Comments on Accepted Changes

Allow Ltd ('Allow')

Deadline 3A – 1st Dec 2020

Drawing Number HE514465	Originator -GHX	Volume -LLO	Rev P08
Location Z1_SW_PR_Z	Type -DR-LR-1004	Role -DR-LR-1004	Number

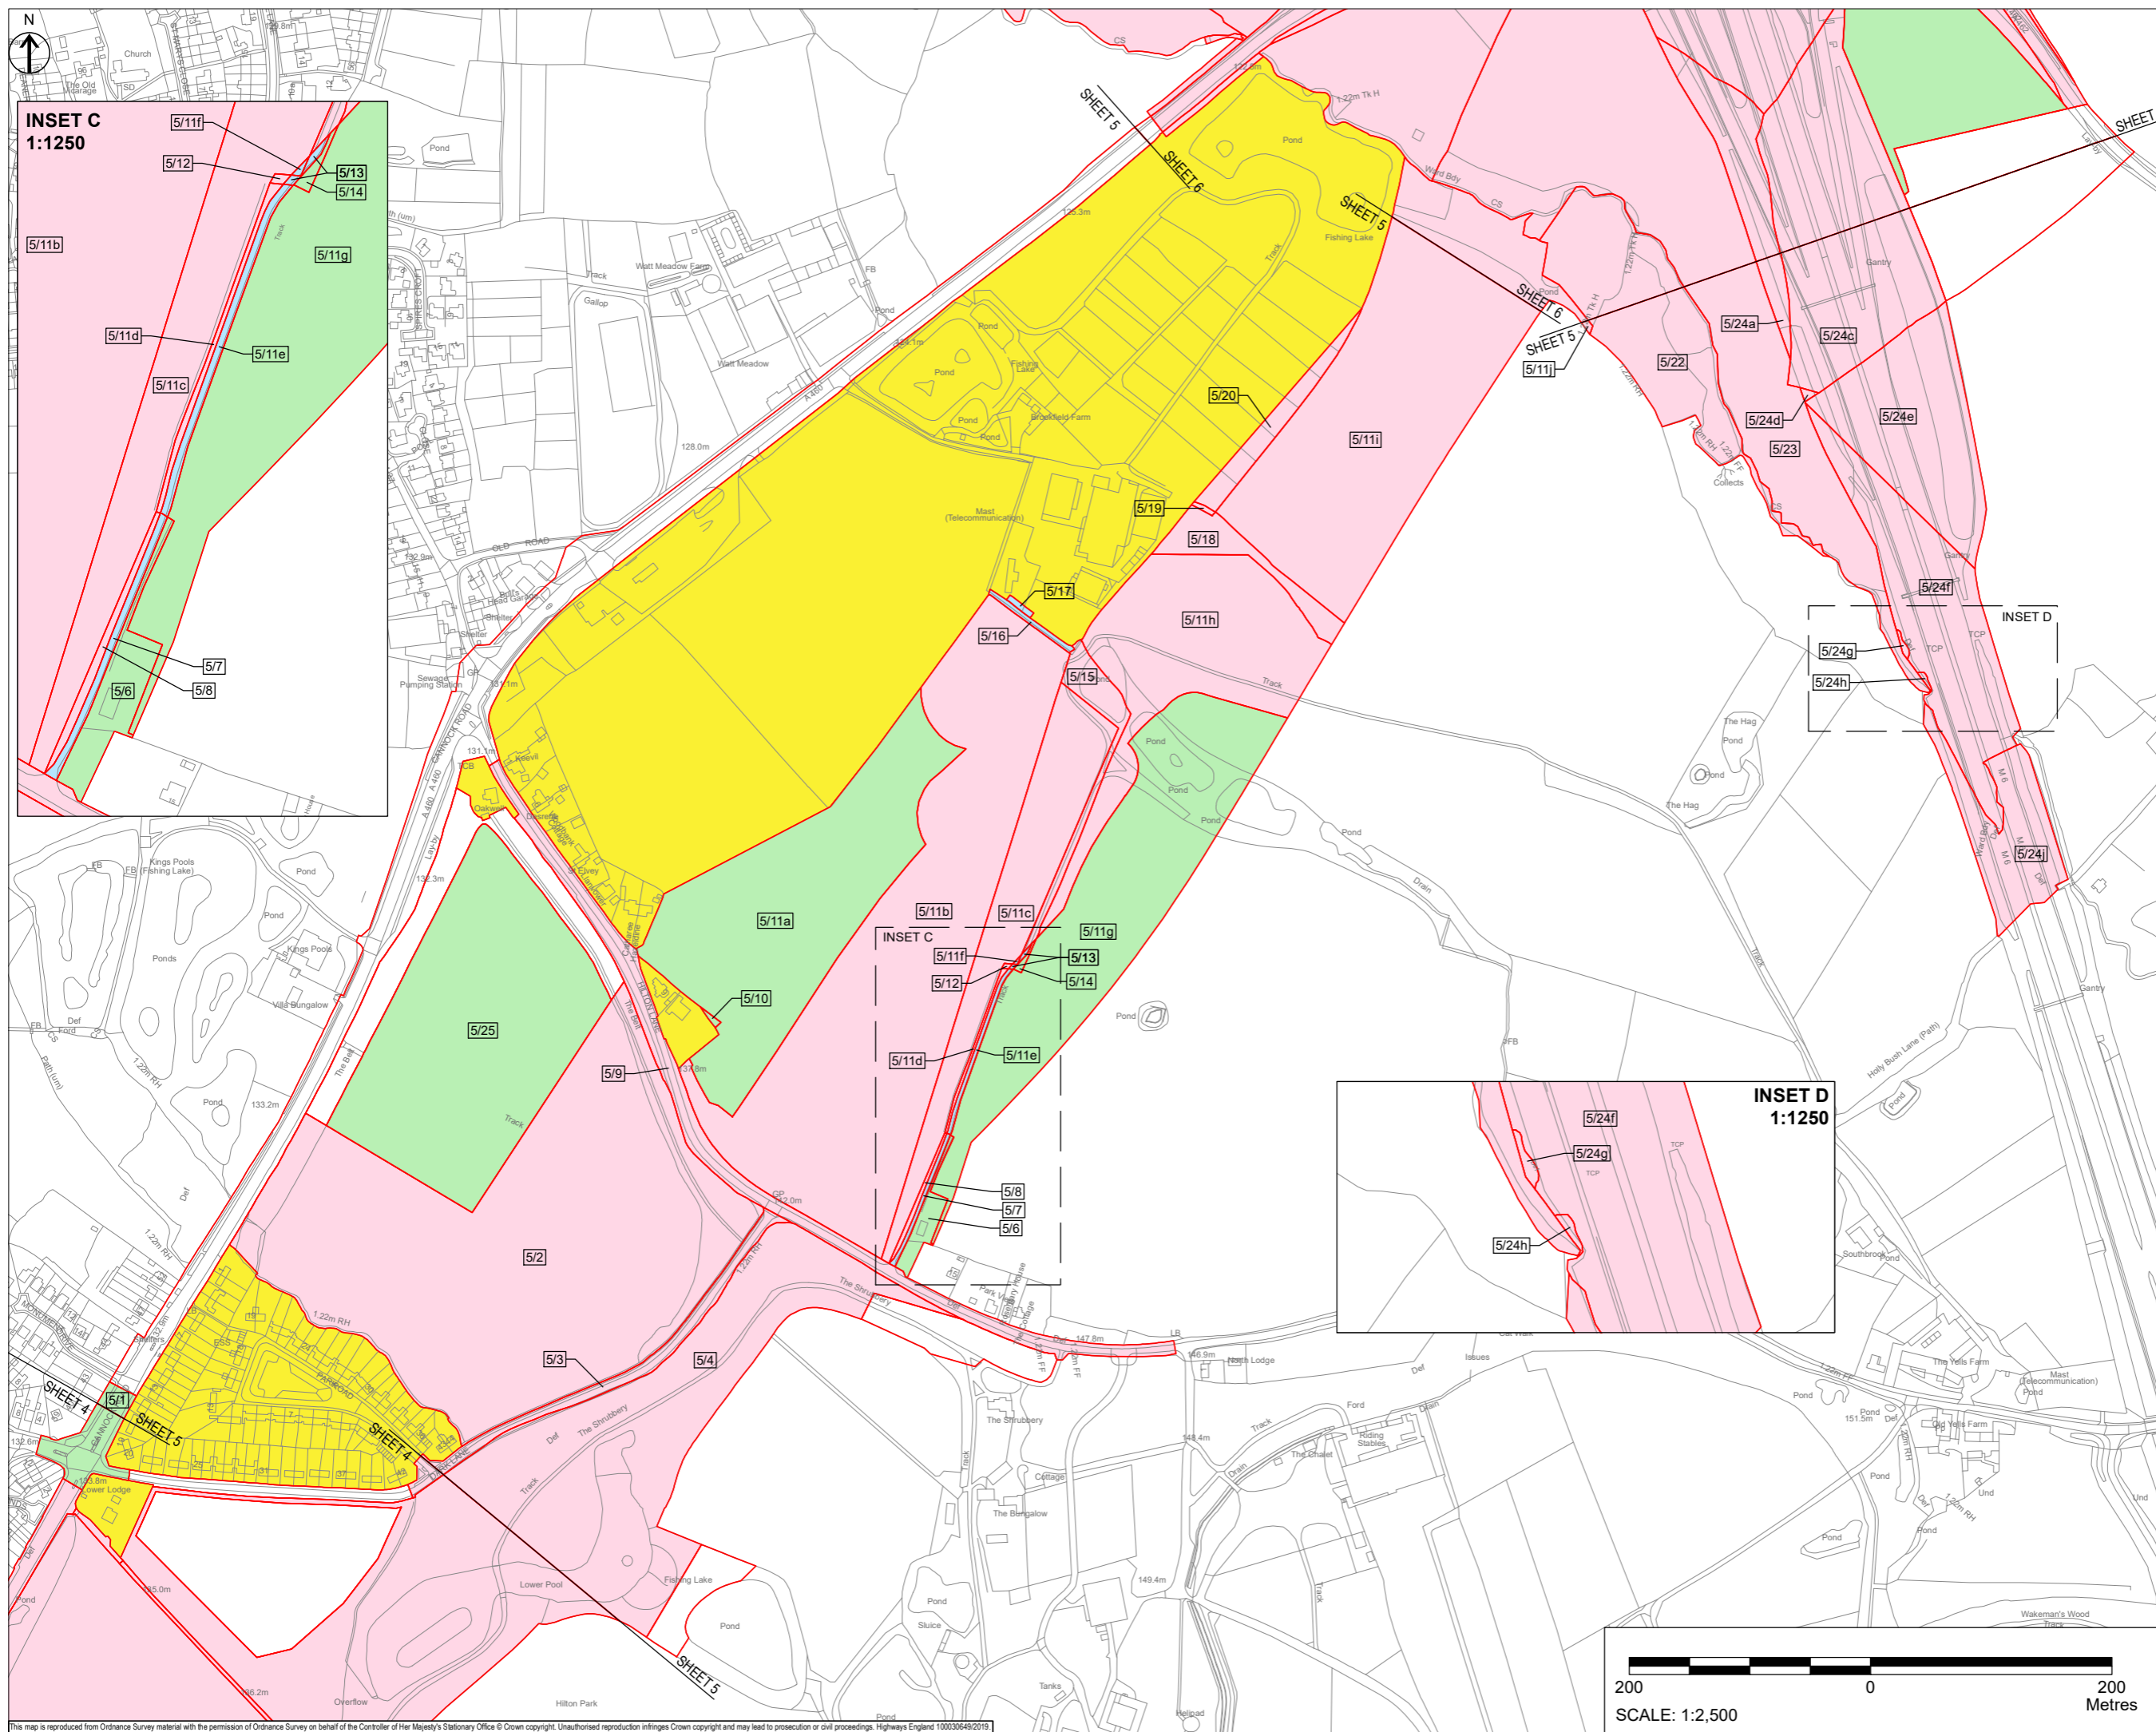
1.1. The removal of land to be acquired compulsorily from plot 4/20c and shown on drawing number HE514465 -GHX -LLO Z1_SW_PR_Z -DR-LR-1004 ('Dwg 1004') supports Allow's position that the extent of land required for ecological mitigation is excessive. An extract from Dwg 1004 is shown below. Allow's Ecologist, Aspect, identified that the Great Crested Newt assessment in the Applicant's Environmental Statement was excessive. It is noted that the removal of the triangular area from plot 4/20c has been removed because the Applicant has this year carried out more recent and accurate Great Crested Newt surveys resulting in less land to be acquired compulsorily for Great Crested Newt ponds. Allow's view remains that the extent of land currently required permanently from plot 4/20c is not necessary or proportionate and in event can be placed on land owned by Allow to the east of the proposed link road.

1.2. Allow's retained land within plot 4/20c shown coloured white within plot 4/20c on Dwg 1004 ('Allow's Retained Land Within Plot 4/20c') has no access. The Applicant seek permanent compulsory purchase powers in respect of all the land within plot 4/20c that abuts Allow's Retained Land Within Plot 4/20c. The consequence is that if the compulsory purchase powers are granted by the Examining Authority Allow will have no access to Allow's Retained Land Within Plot 4/20c. Allow ask that the Examining Authority modify plot 4.20c so that it provides suitable access along both Dark Lane and plots 4/20a and b.

1.3. No adequate reasons have been provided to explain why the land to the north of Allow's Retained Land Within Plot 4/20c that fronts Dark Lane is required compulsorily. There is no indication that this strip of land will provide ecological mitigation or the purpose for which the Applicant wishes to acquire this strip of land permanently using compulsory purchase powers. If it is the case that the Applicant wishes to upgrade existing fencing along Dark Lane

it is not necessary for such land to be acquired compulsorily. The environmental mitigation plans show 6 existing trees and a proposed new hedge along the boundary of Dark Lane. The Examining Authority should note that 5 of the 6 trees are located on Dark Lane and not within the strip of land in Allow's ownership the Applicant wishes to acquire compulsorily.

- 1.4. The boundary currently has a high fence to combat fly tipping which is a problem within the locality. The Applicant notified Allow in a meeting on 24.9.20 that they had received requests from the Parish Council to alter the existing metal fence to something more visually acceptable. Allow confirmed we would be receptive to suggestions but that fly tipping is a problem. Changes to this fence would need to be addressed by the Applicant and agreed with Allow to prevent fly tipping issues being a problem in future. This can be achieved by negotiation and freehold acquisition is not considered necessary.

- 1.5. Environmental mitigation plans illustrate a proposed hedge SH08 along this boundary, although this was not mentioned by HE in the meeting on the 24.9.20. A new hedge is likely to be an inadequate barrier to the anti-social behaviour, such as fly tipping, ongoing in the vicinity. The inadequacy of a hedge to address fly tipping is illustrated on the ground by the existing hedge on the car boot field (plot 5/2) along Dark Lane, which suffers from fly tipping.

Drawing Number HE514465	Originator -GHX	Volume -LLO	Rev P08
Location Z2_SW_PR_Z	Type -DR-LR-1005	Role -DR-LR-1005	Number P08

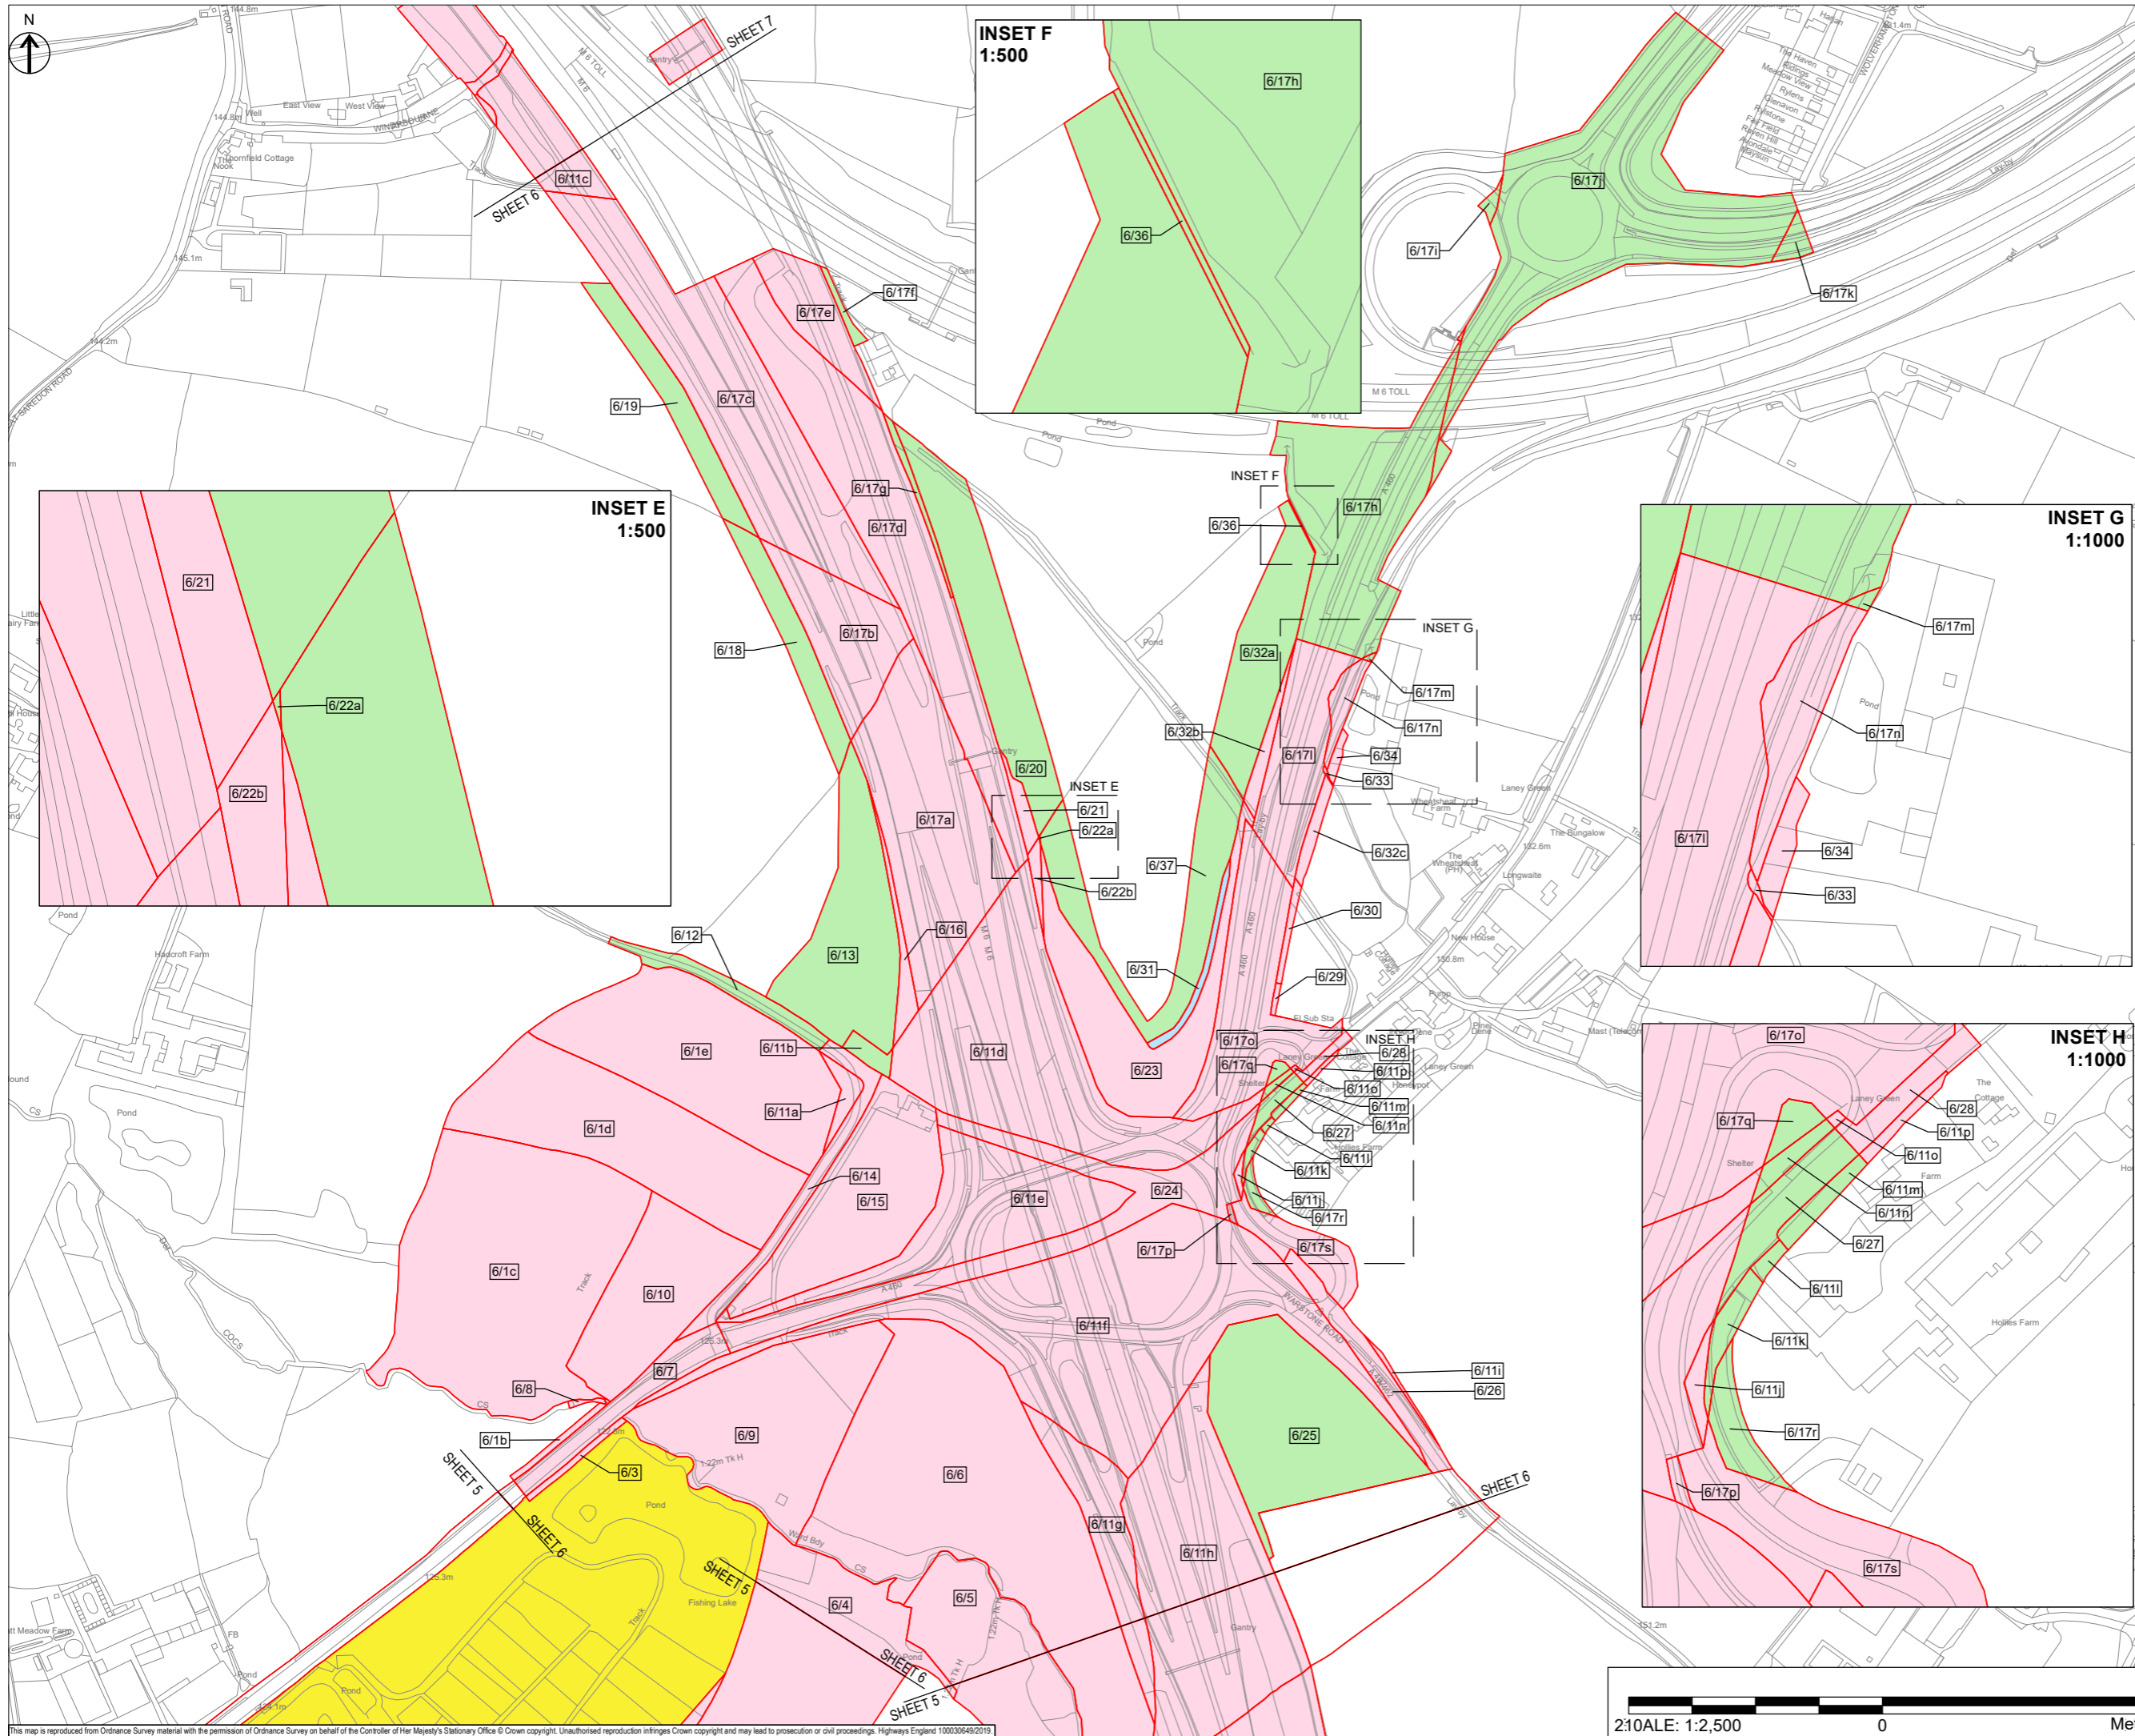
3.1 The reduction of land taken from plot 5/2, to form 5/25 (to be acquired temporarily) shown on drawing number Drawing Number HE514465 -GHX –LLO Z1_SW_PR_Z -DR-LR-1005 (Dwg 1005) and below.

3.2 It is considered that the Approved Changes have not gone far enough and the extent of plot 5/2 required permanently should and can be reduced further. Representations have been made at deadline 3 in this regard. Additional representations made in the consultation to scheme changes made on the 21st September 2020 remain valid, with particular reference to point 4 of section R, being comments upon the rational to Changes to the Environmental Masterplan.

3.3 The field that is comprised in 5/2, 5/25 and 5/26 currently has an entry gateway onto the A460 and exit gateway onto Dark Lane to facilitate the car boot sales which take place on the land. Entry from A460 and exit access provisions from Hilton Lane and the A460 are required for continued use of 5/25 as a car boot field and potential future uses. As part of the Approved Changes there is no longer any provision for any vehicular exit from Dark Lane. This will have a detrimental impact on the car boot sales and any future business activity on plot 5/25. We propose that the Applicant provide provision for exit from Hilton Lane to enable existing and future business activities from plot 5/25 and where applicable plot 5/26 to continue unhindered.

3.4 Allow also consider that plot 5/25 could be extended further given that the extent of ecological mitigation on plot 5/2 remains excessive and in any event more mitigation could be placed on land to the east which has not been assessed correctly for the reasons provided by Allow's Ecologist and Historic Landscape Consultant.
